From: Amy Myer <Amy.Myer@arun.gov.uk>
Sent: 24 June 2020 17:46
To: Planning.Responses <Planning.Responses@arun.gov.uk>
Cc: Daniel Vick <Daniel.Vick@arun.gov.uk>
Subject: FW: AL/34/20/PL & AL/35/20/L - Norton Farm House - EXTENSION OF TIME/PLANNING COMMITTEE CASE

From: David Bennett [REDACTED]
Sent: 24 June 2020 15:24
To: Amy Myer <Amy.Myer@arun.gov.uk>
Subject: Re: AL/34/20/PL & AL/35/20/L - Norton Farm House - UPDATE

LOCATION PLAN AND BLOCK PLAN

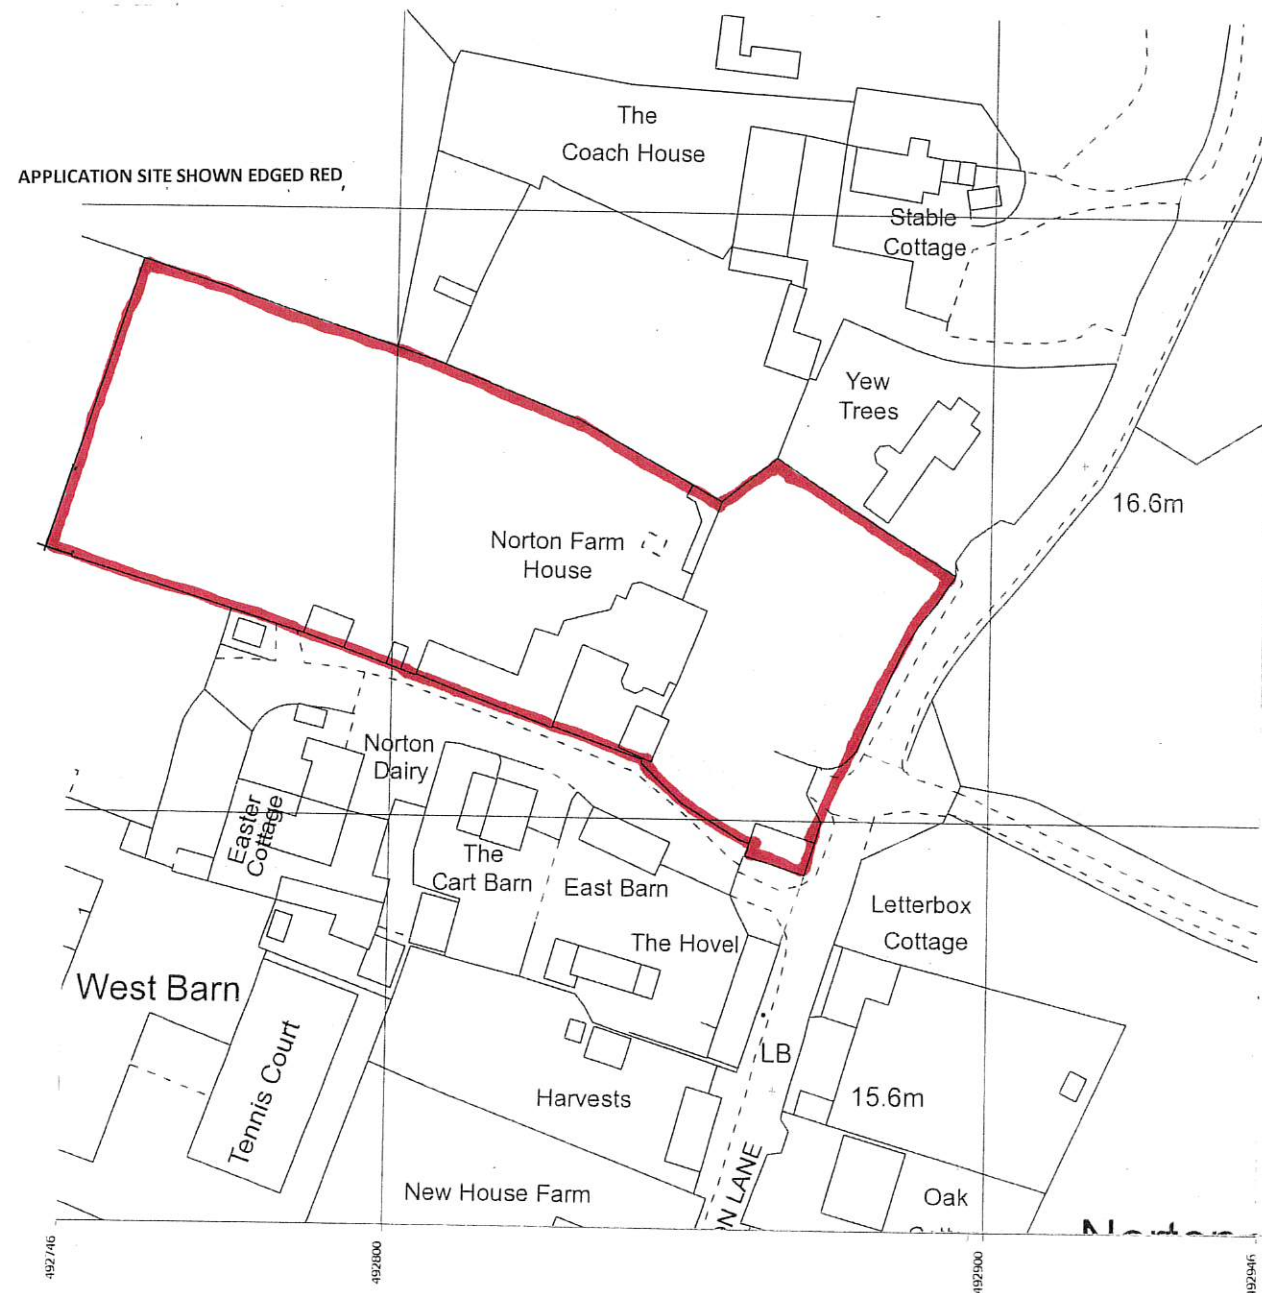
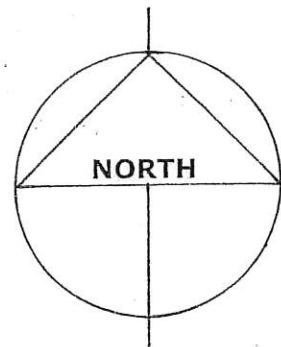
1. Vehicle access plan – please amend location plan and block plan with drawing title 'Vehicle access plan' and then on block plan image show edged in red the application buildings and with the double gates and vehicle access marked in red with arrow and annotation and same on site location image 'existing double gate access to site' in red with arrow, so it's all clearer (since we received a neighbour objection on this matter)
2. Site photos – of rest of the site, farmhouse, courtyard where existing playroom building is, area where new garage will go
